**Consultation Response from KC,  
Lead Local Flood Authority**

**2025/93500 adj, 208, Yew Tree Road, Birchencliffe, Huddersfield, HD2 2EQ**

**Discharge of details reserved by conditions 6 (Phase II Intrusive Site Investigation Report), 7 (Remediation Strategy), 14 (Temporary drainage), 16 (drainage strategy, 17 (drainage attenuation), 23 (construction traffic), 26 (EVC) on previous permission 2018/90151 for outline application for erection of residential development**

**Date Responded: 1<sup>st</sup> May 2026**

A Plan updated in response to LLFA comments on discharge of planning conditions application		10-02-26	PSGBS
Rev	Details	Date	Drwn.
Newett Homes			
Yew Tree Road - Birchcliffe			
Surface Water Management plan			
Dwg No. : 7003-03 Rev A			
Date : 07-11-25			
Scale : Plan 1:500 @ A1			Drawn : PSGBS

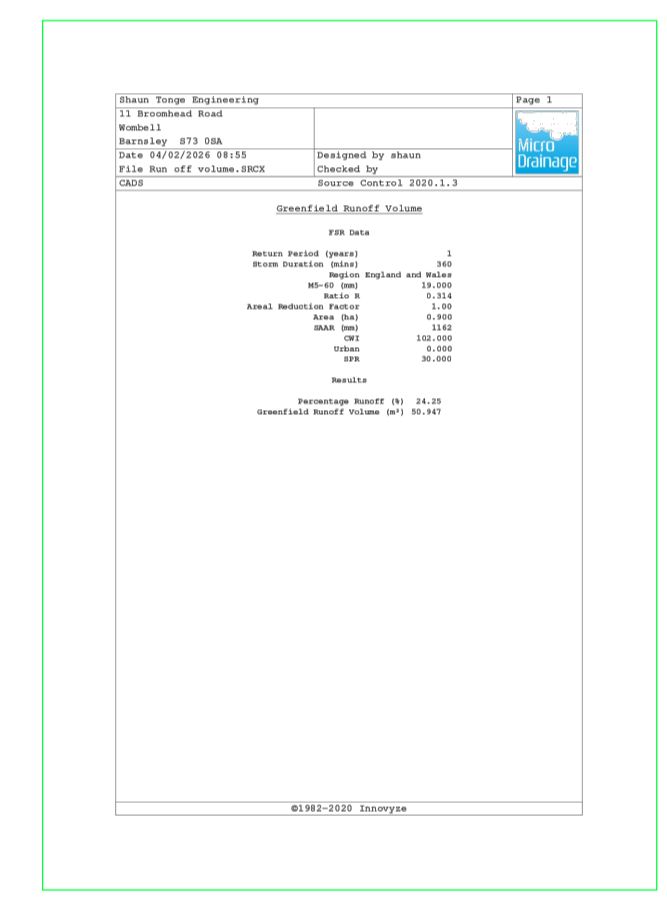
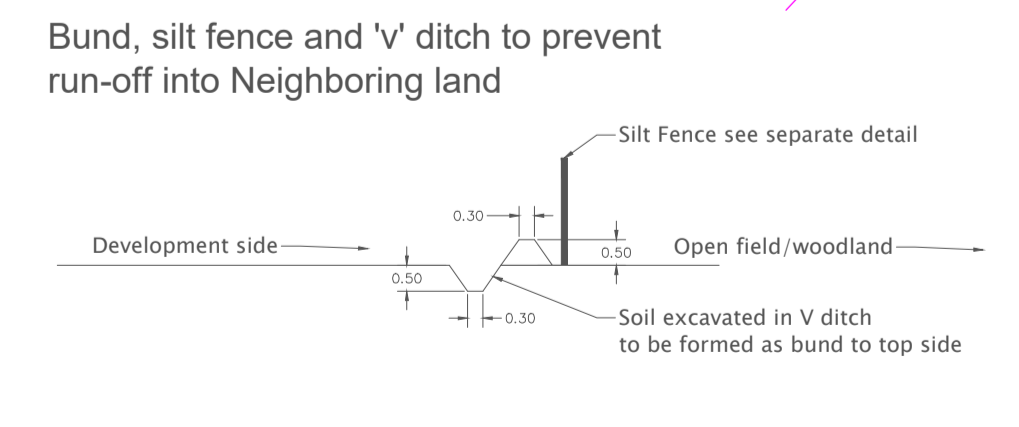
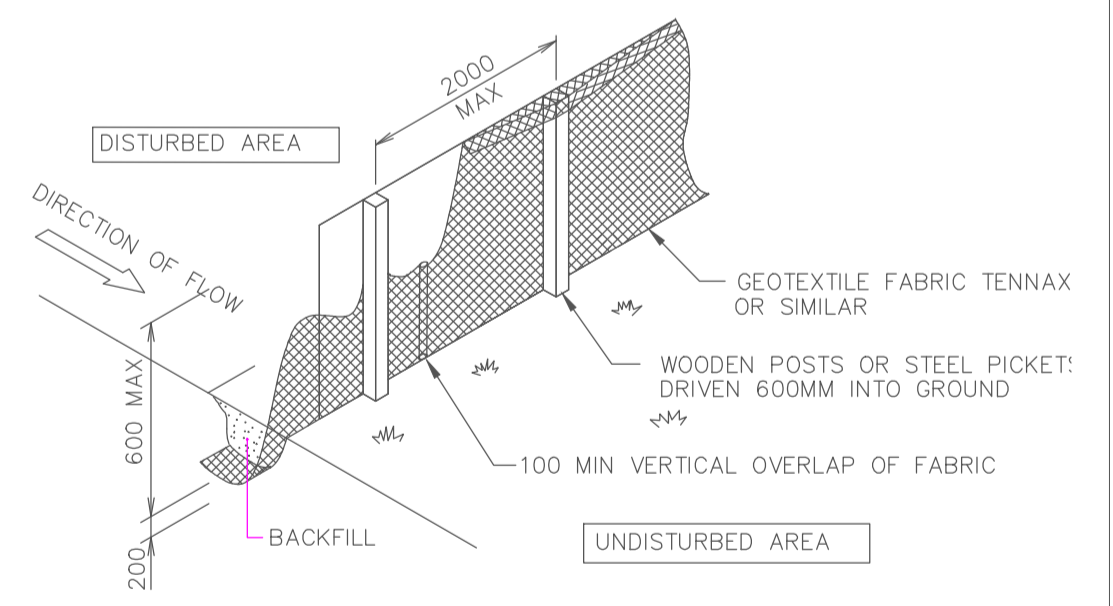
Plans and cross sections of attenuation has been provided including maintenance plans for the SUDS up to the point of adoption and a temporary drainage plan.

**We recommend that both these conditions are now discharged.**

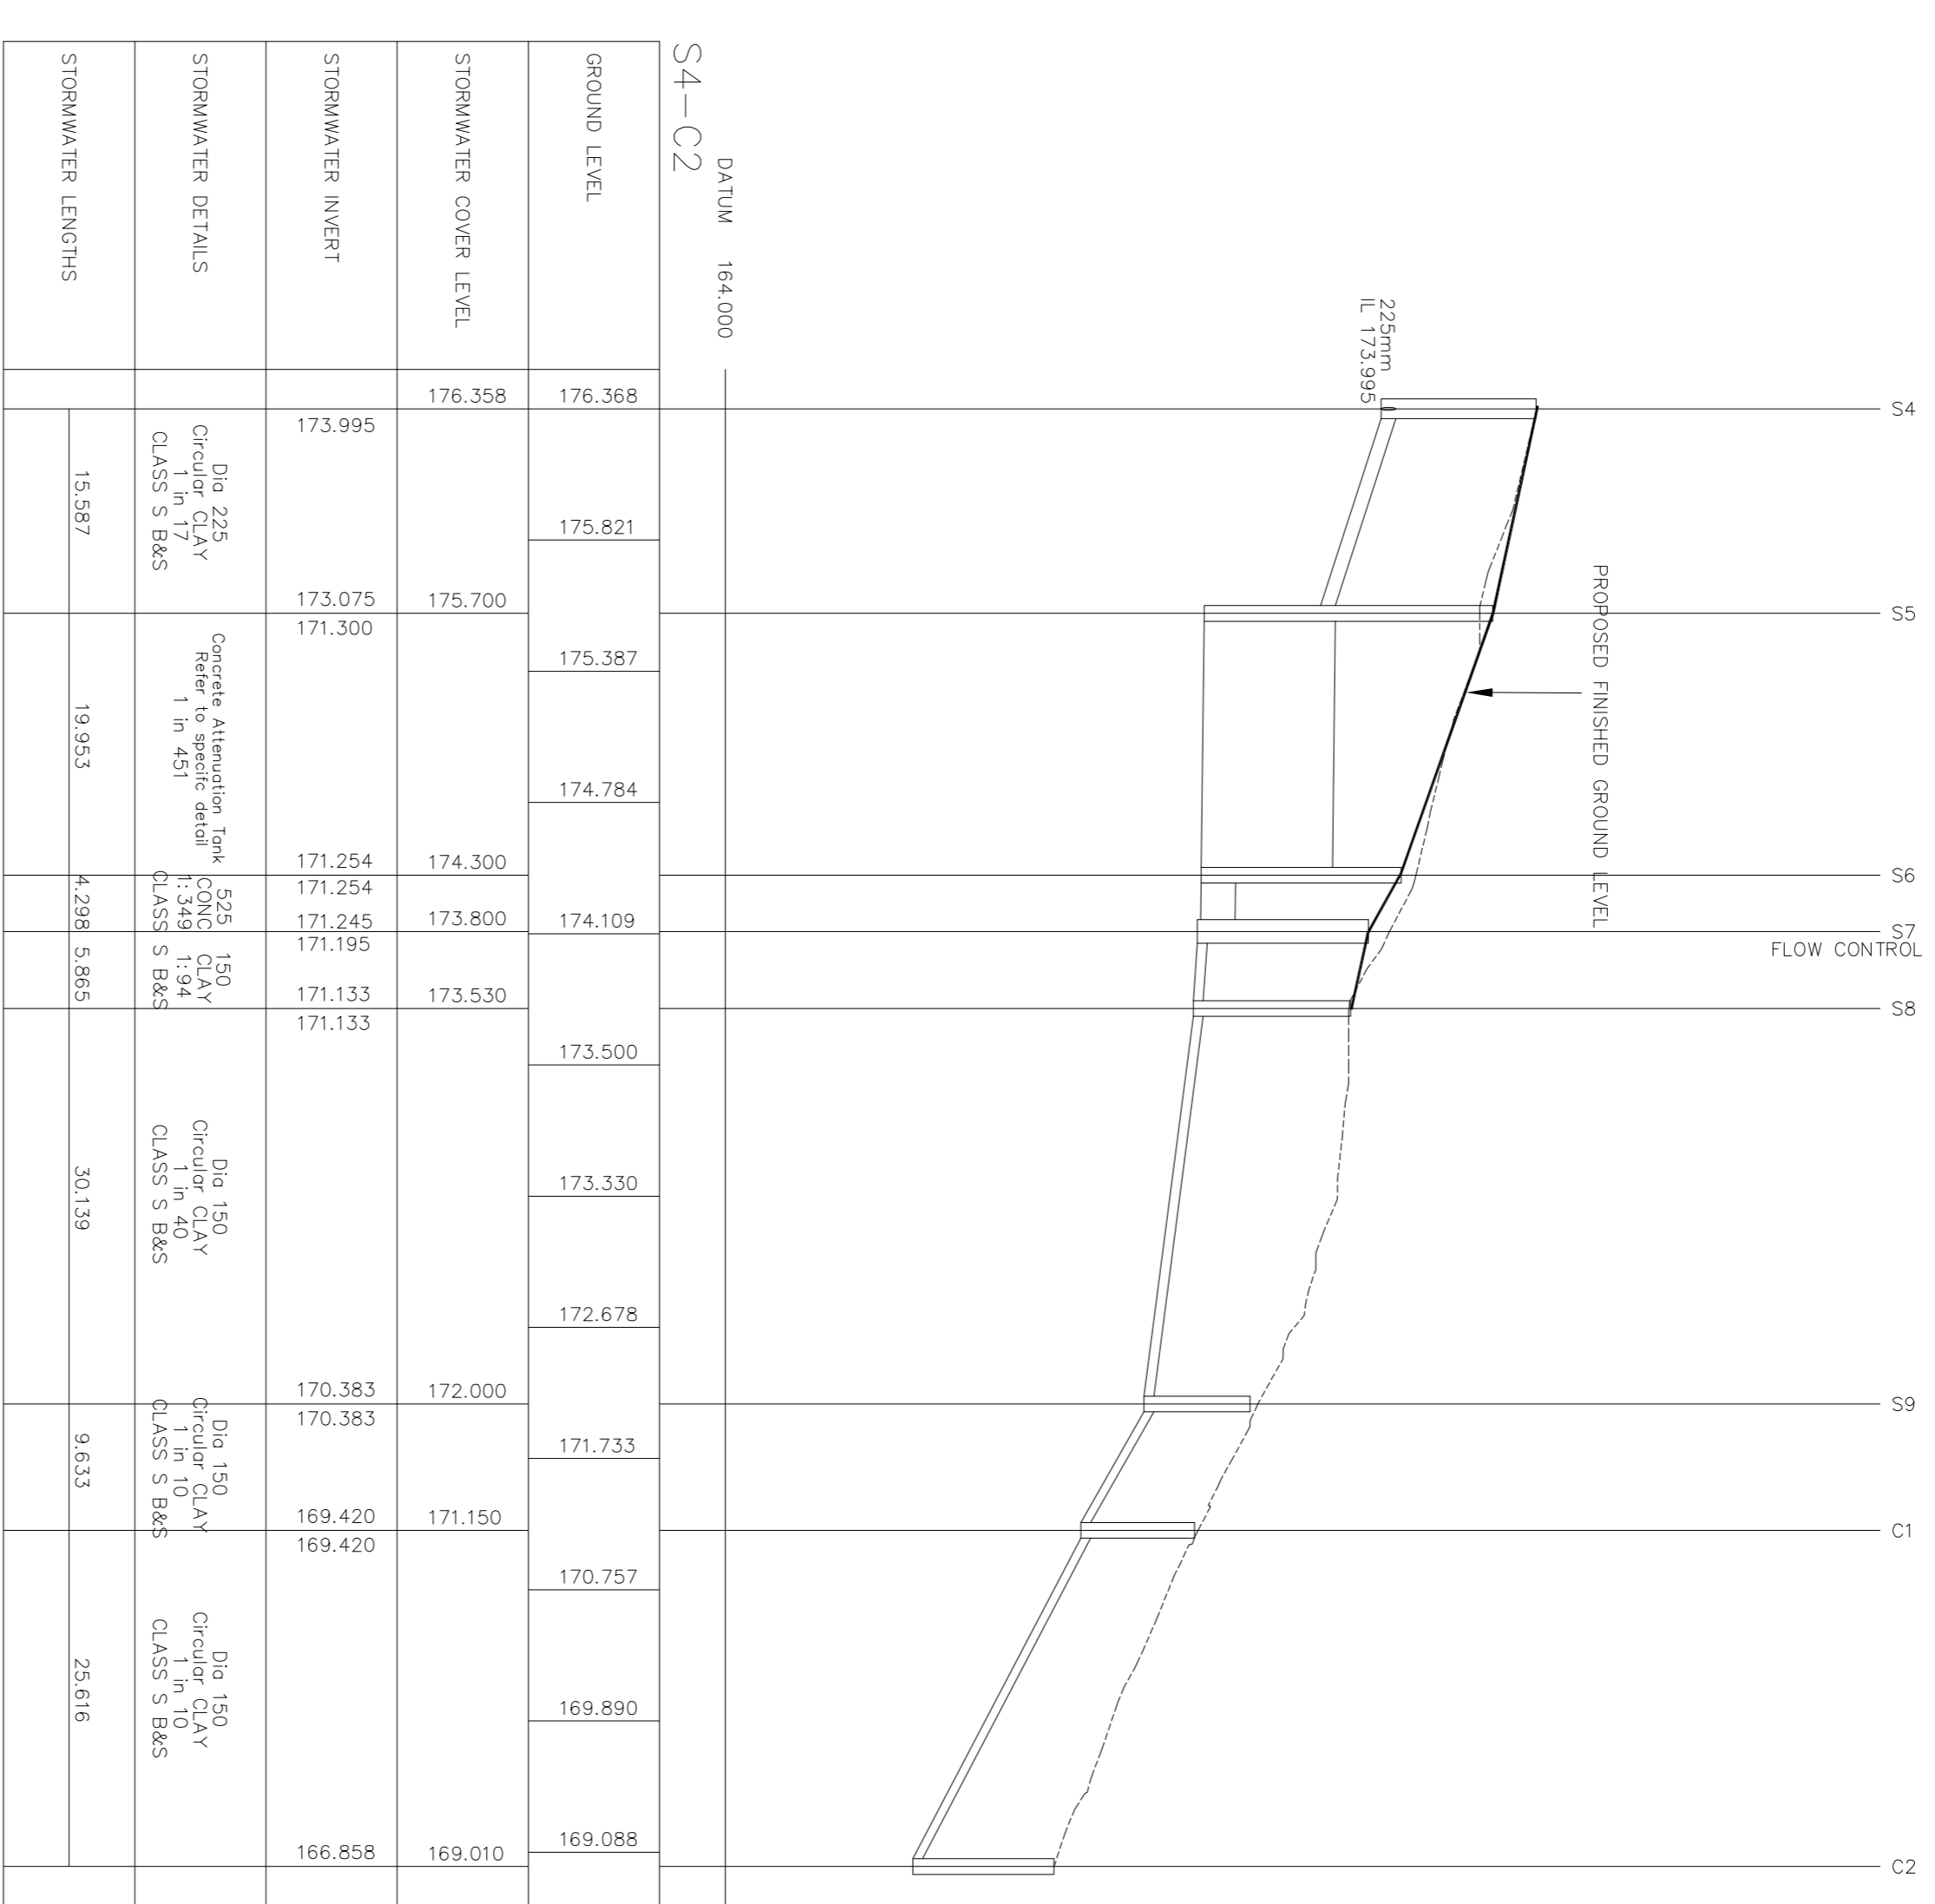
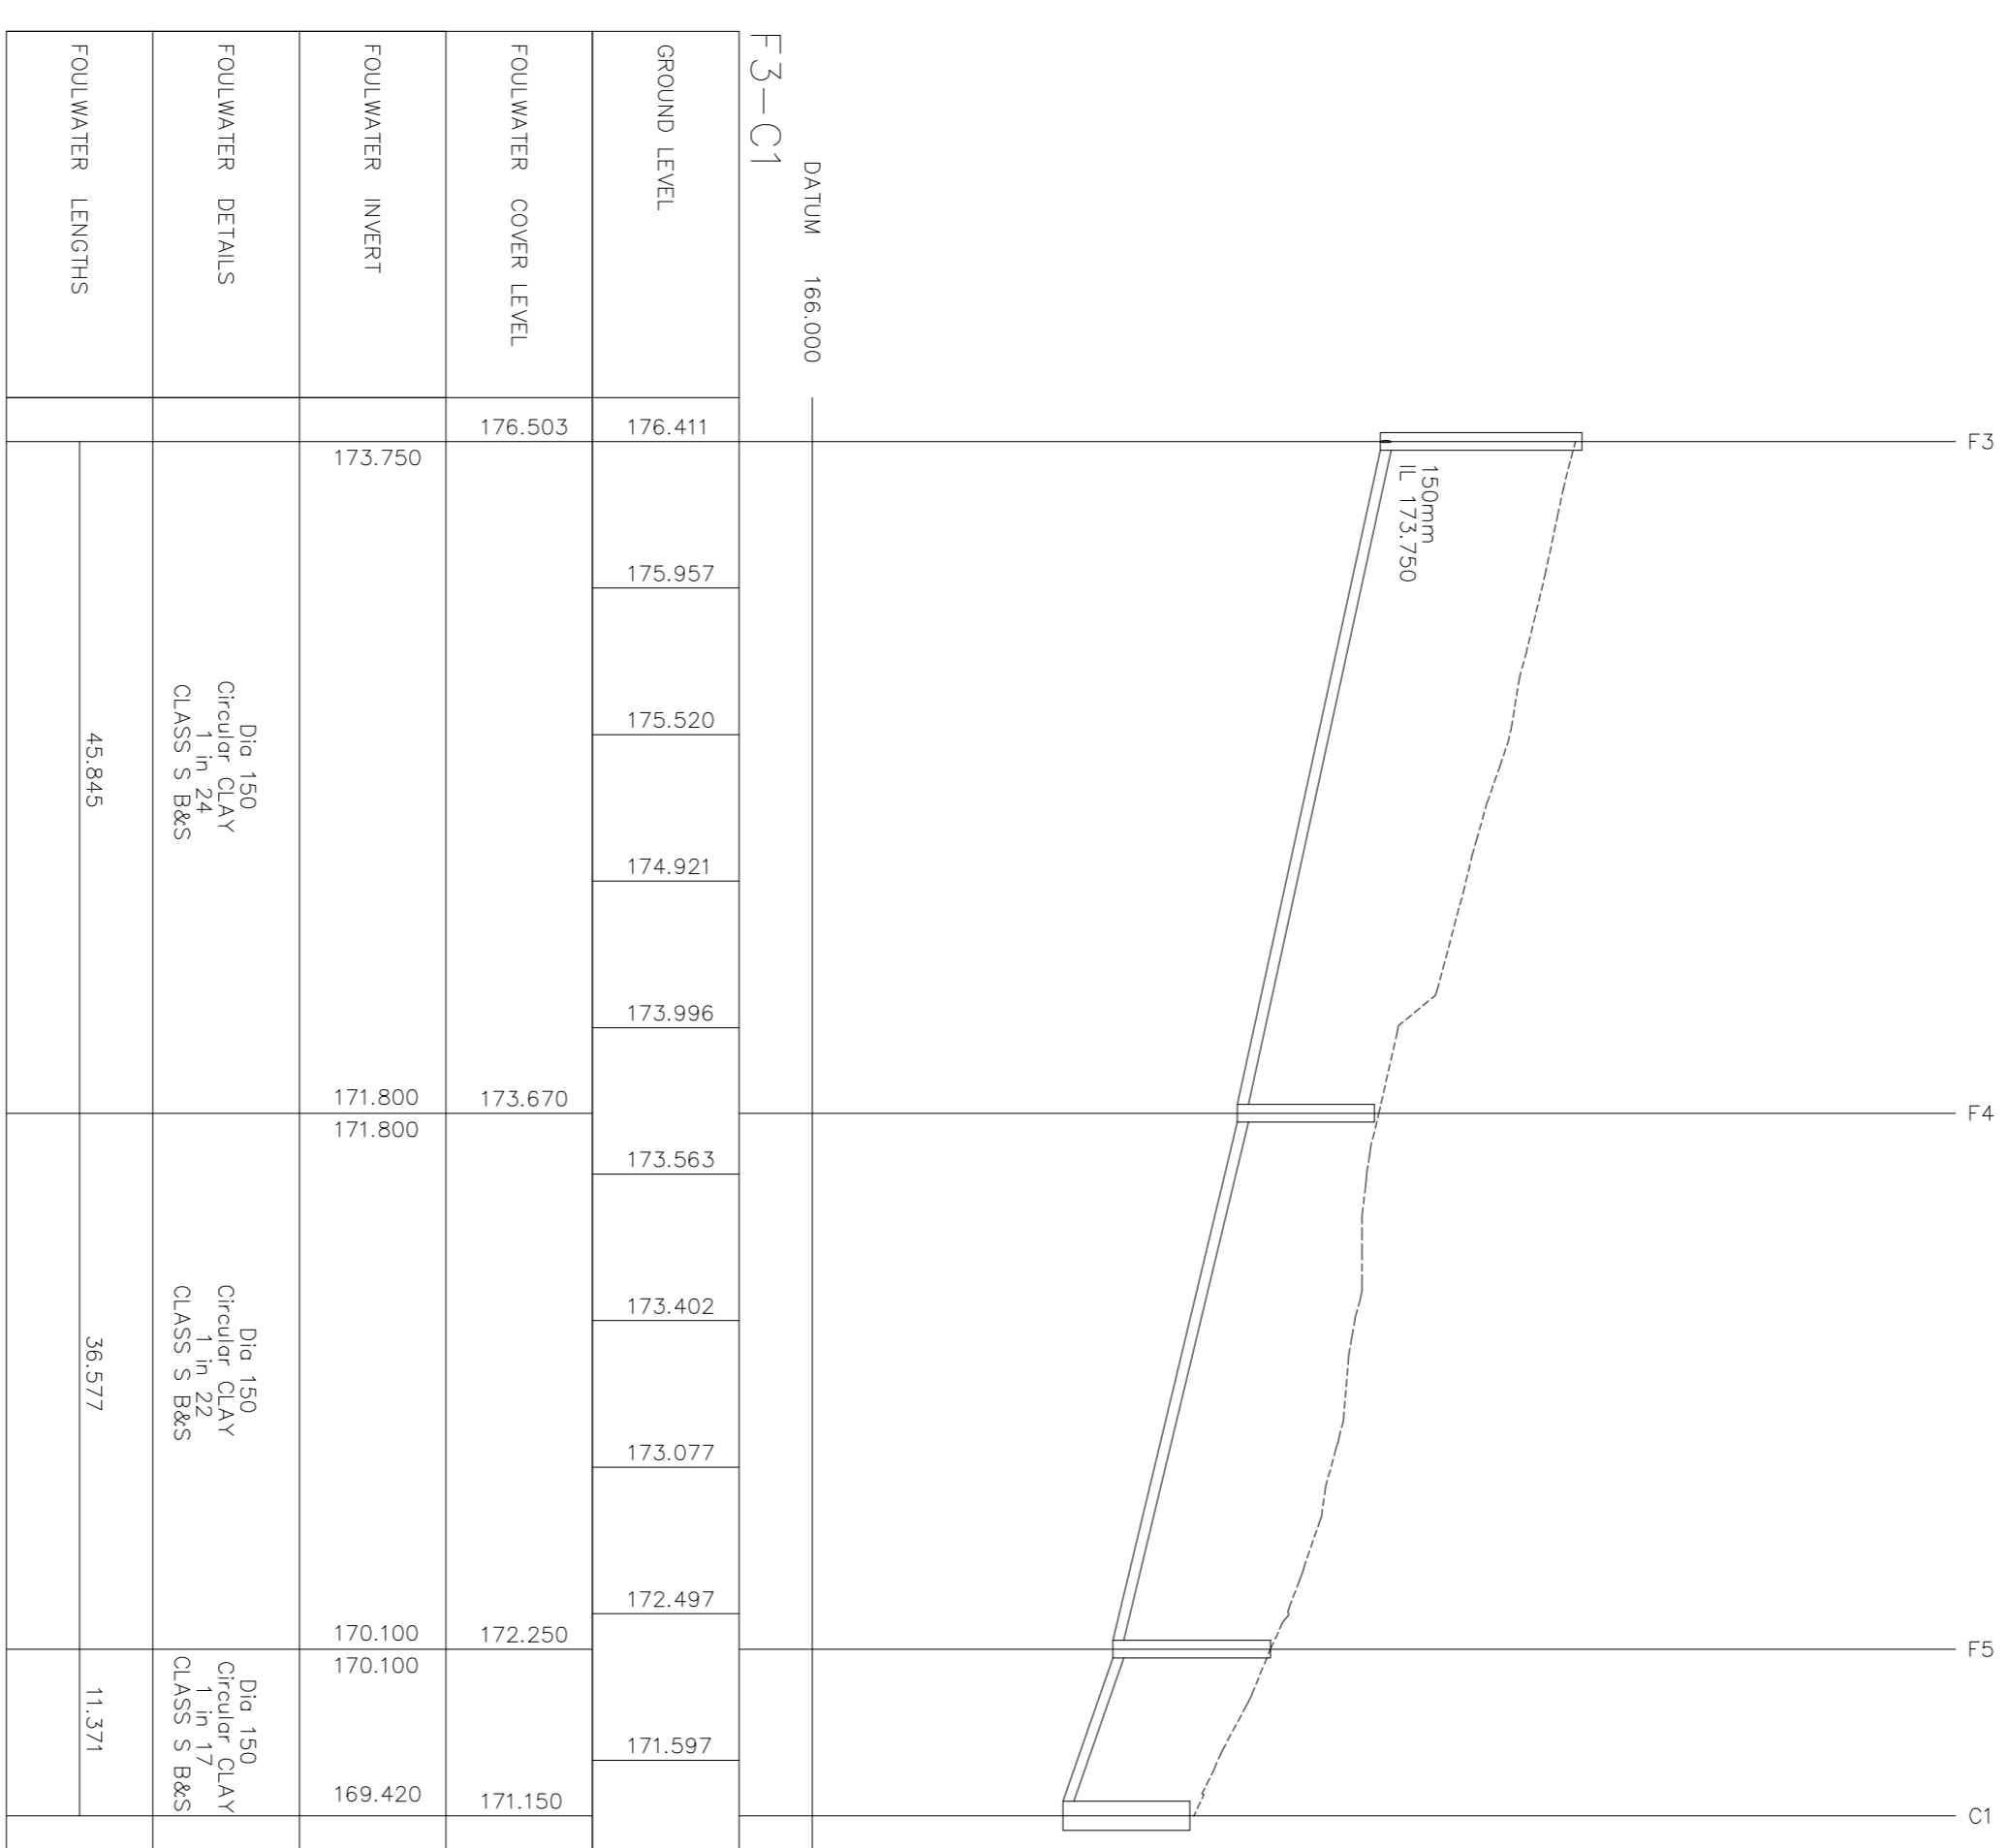
The applicant has now submitted full hydraulic calculations that are accepted alongside a coloured impermeable area plan.

Flood routing shows an engineered channel along the private driveway outside plots 6 and 7 that protects them in blockage scenarios.
